Arun District Planning Department

Further to the response posted by Mr and Mrs Malcolm Jenkins on 22/1/19 regarding objections to planning application FG/220/18/PL.

PROPOSED NORTH (REAR) ELEVATION 1:50.

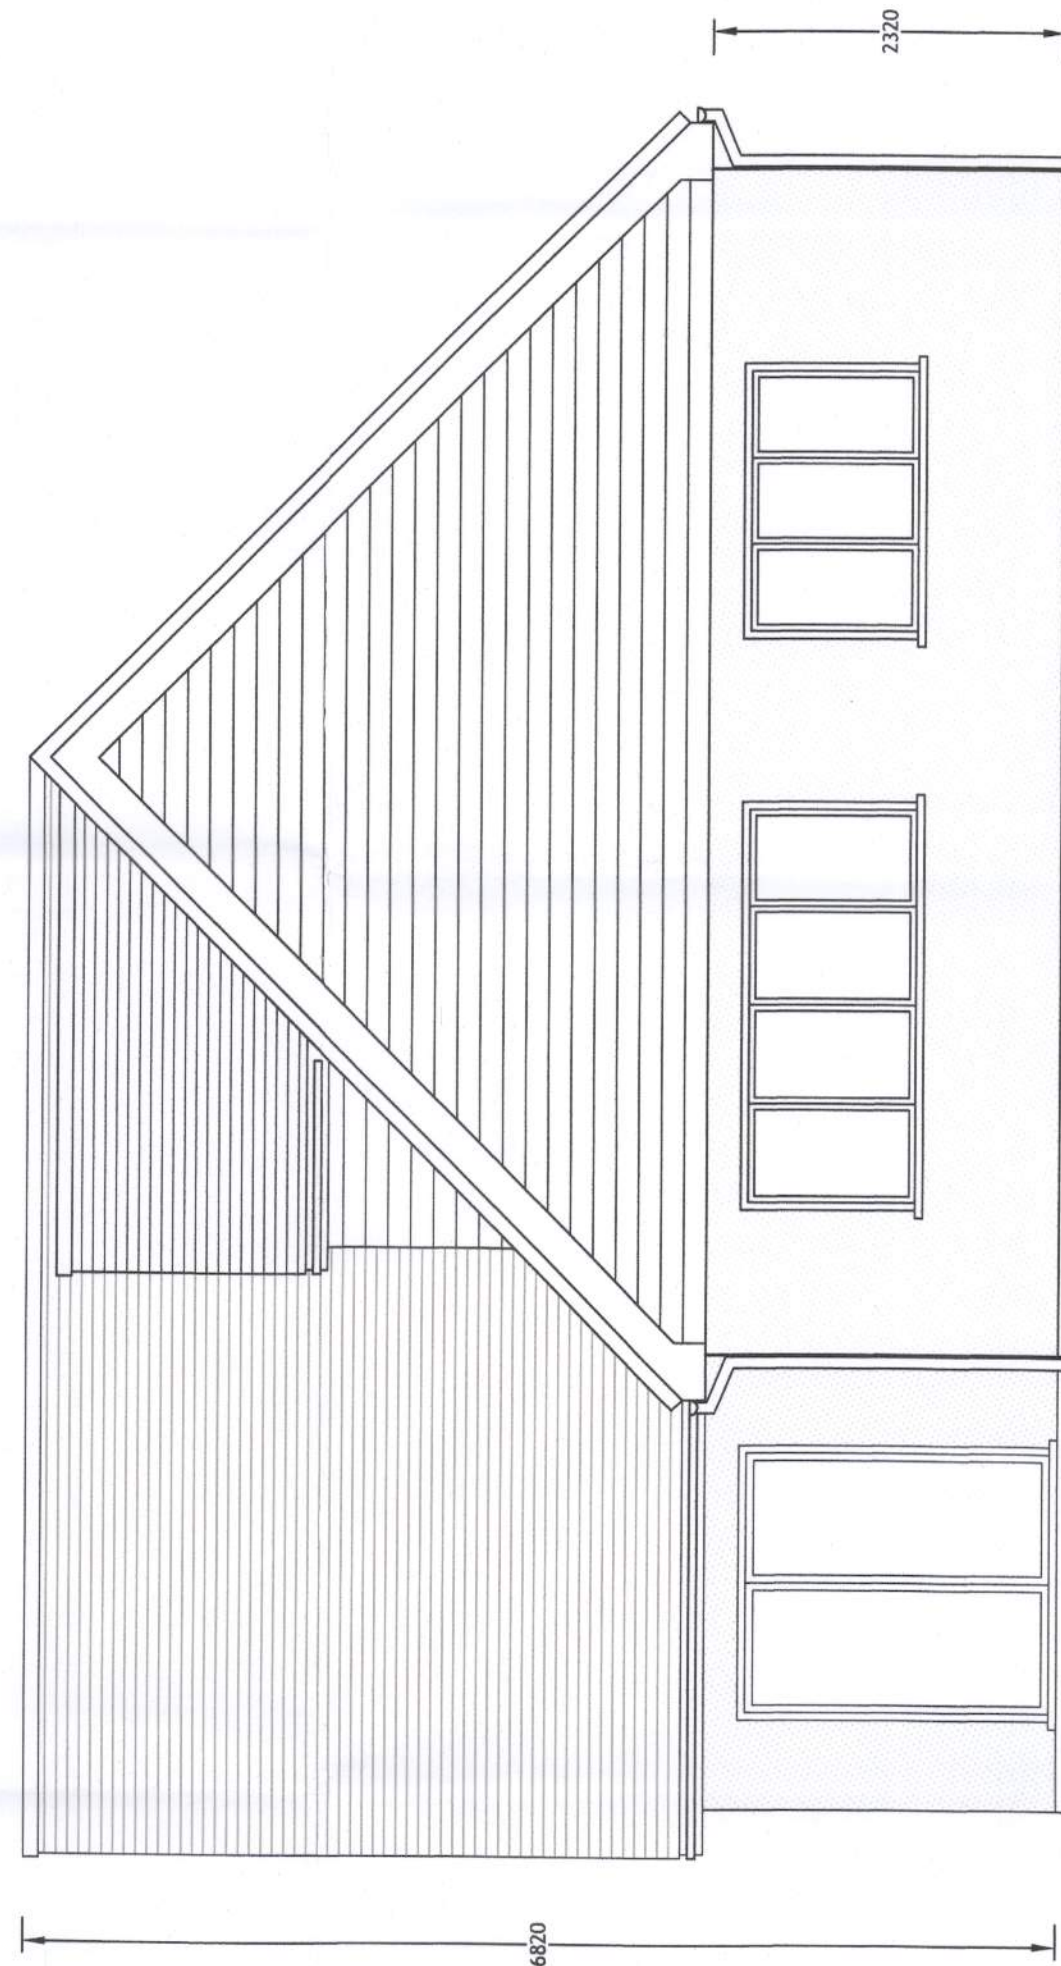
The consequence of the design of the new house and the changes to Elm Lodge means that 4 full length Juliette Balcony windows would directly face and intrusively overlook our house and garden, comprehensively affecting our privacy. We note that these windows will have 'mirror foil' to ensure the privacy of the occupants. Do we not have the same rights?
